Henge Close, Adderbury, OX17 3GA

Planning Application 19/02796/FULL OS Parcels 3309 & 4319 adjoining LNMR

Further to our previous letter of objection earlier this year please find below our additional response to the latest published amendments which include the site layout, car park lighting, roller shutters to the pavilion, MUGA fencing, ball stop fencing and additional tree and hedge planting.

1 North Elevation
1 : 100

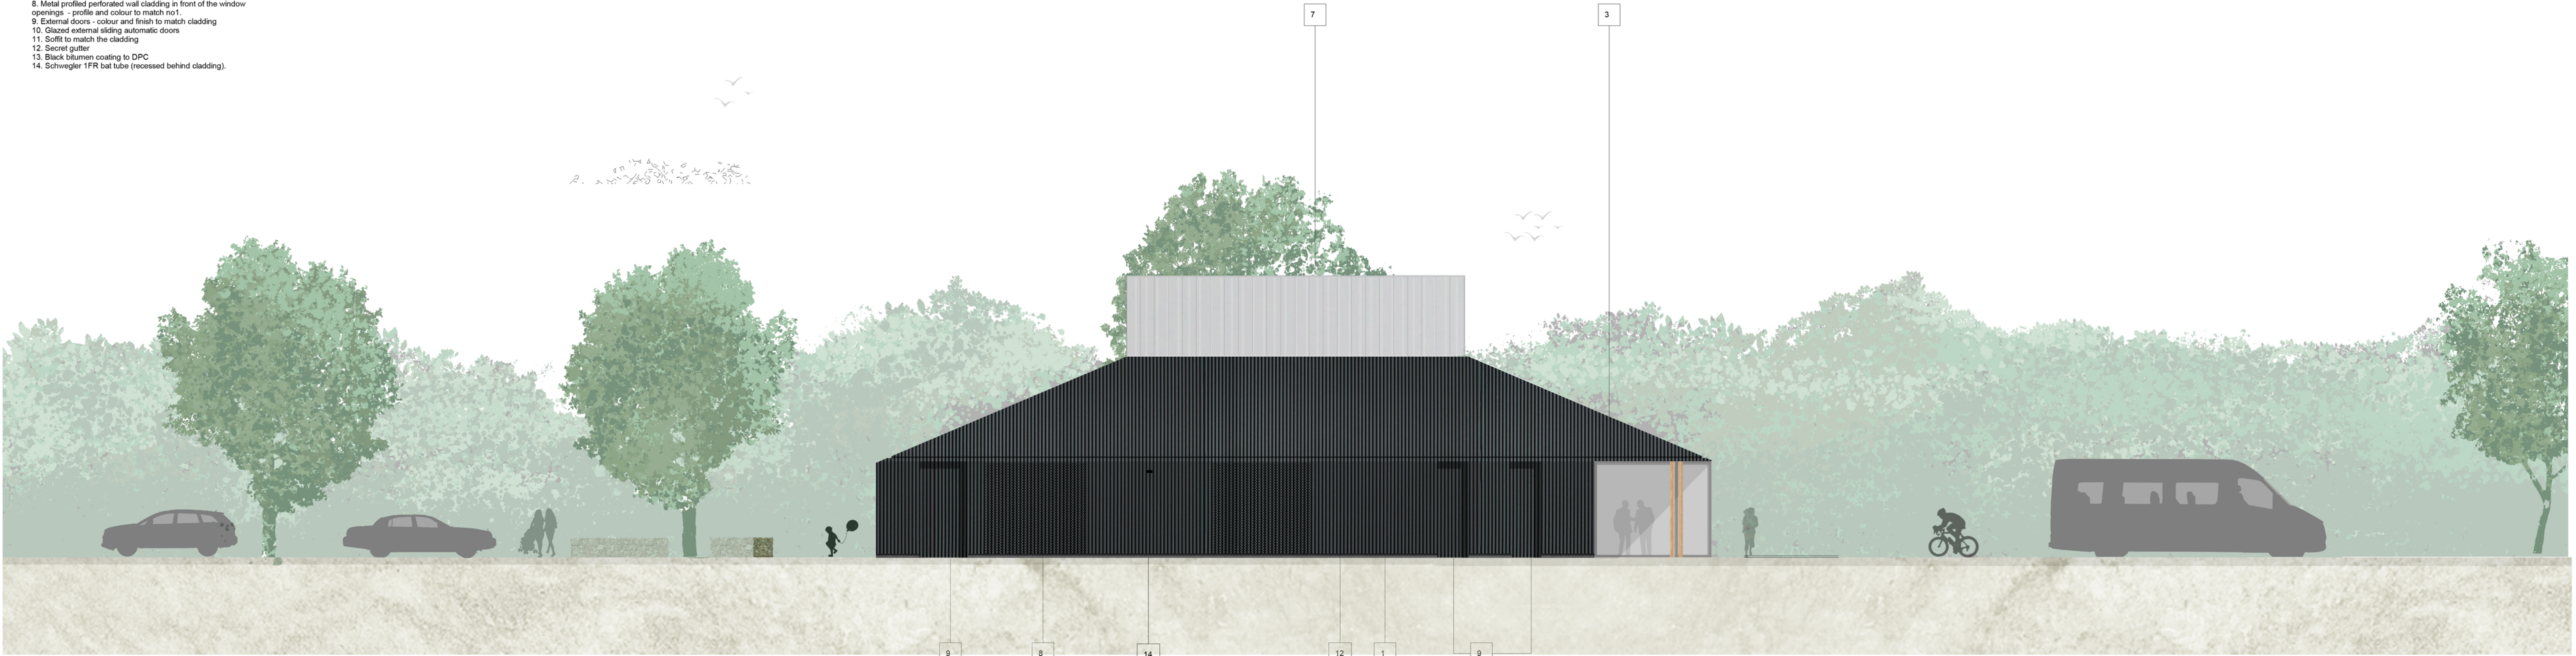
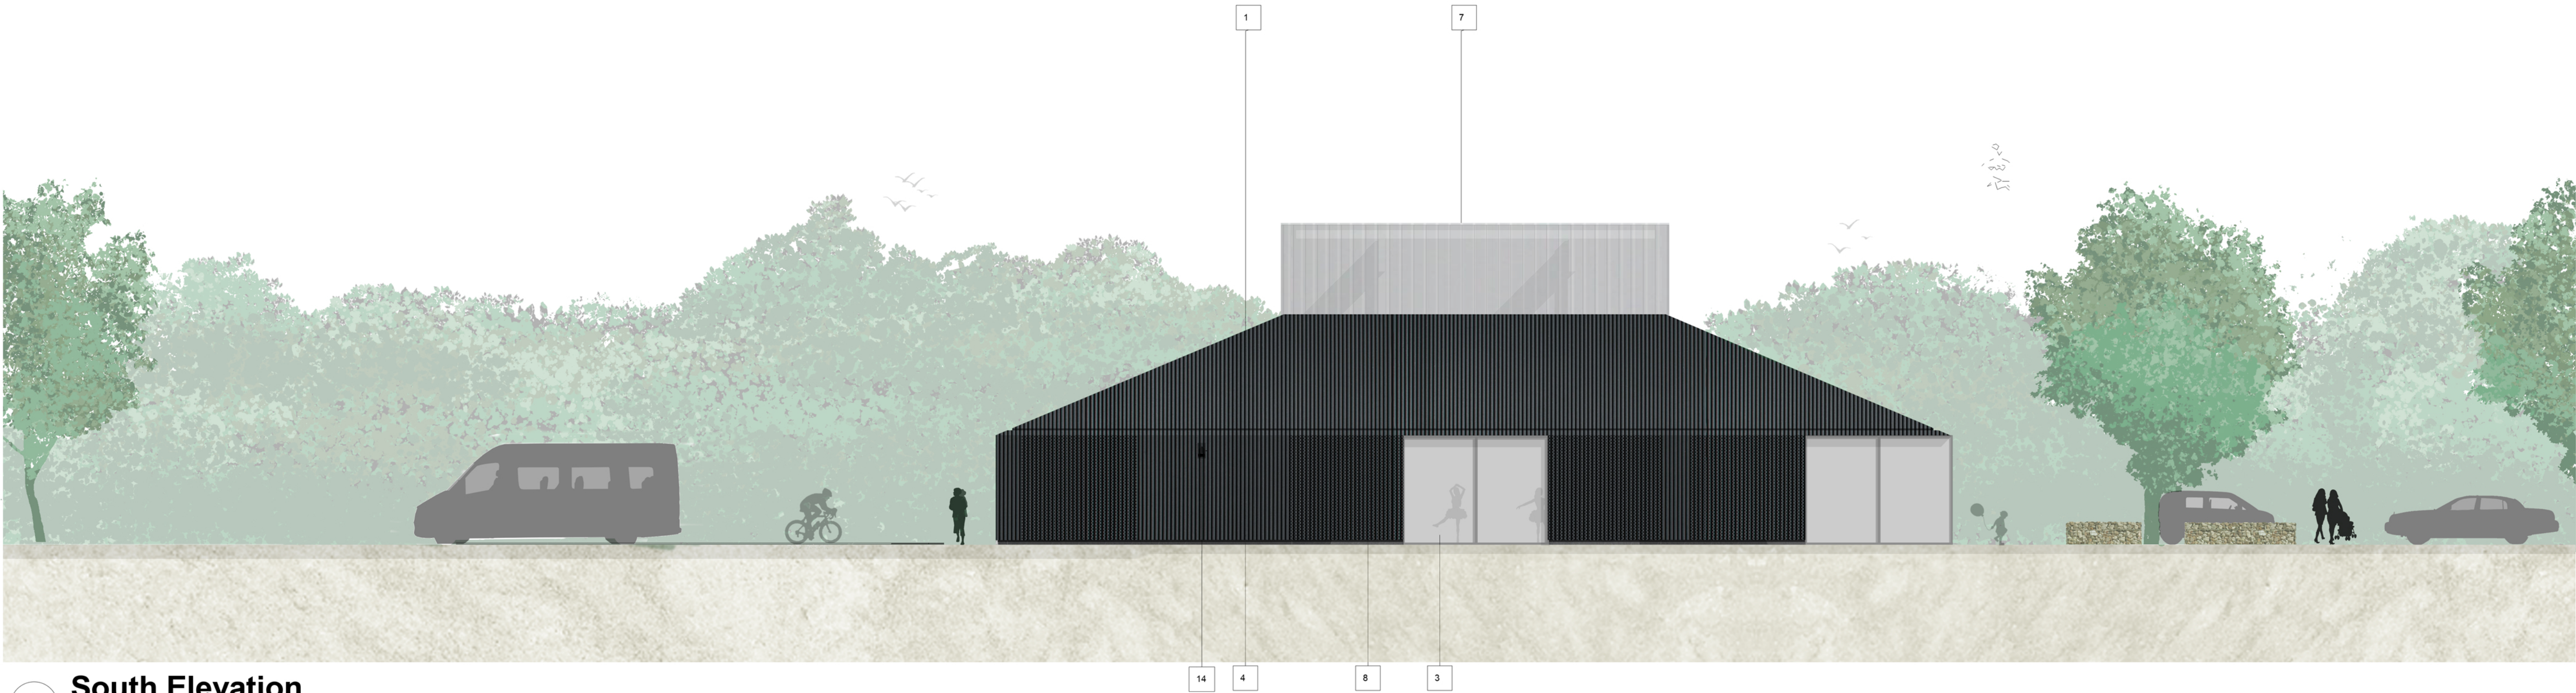
- We consider the proposed external facings of the pavilion and its construction materials ugly and inappropriate. Dark metal shutters are more suggestive of a penal facility than a vibrant community centre. The designers' claim that the dark colour will recede into the landscape like a rural barn are hard to reconcile with their assertion that it will also make a bold statement.
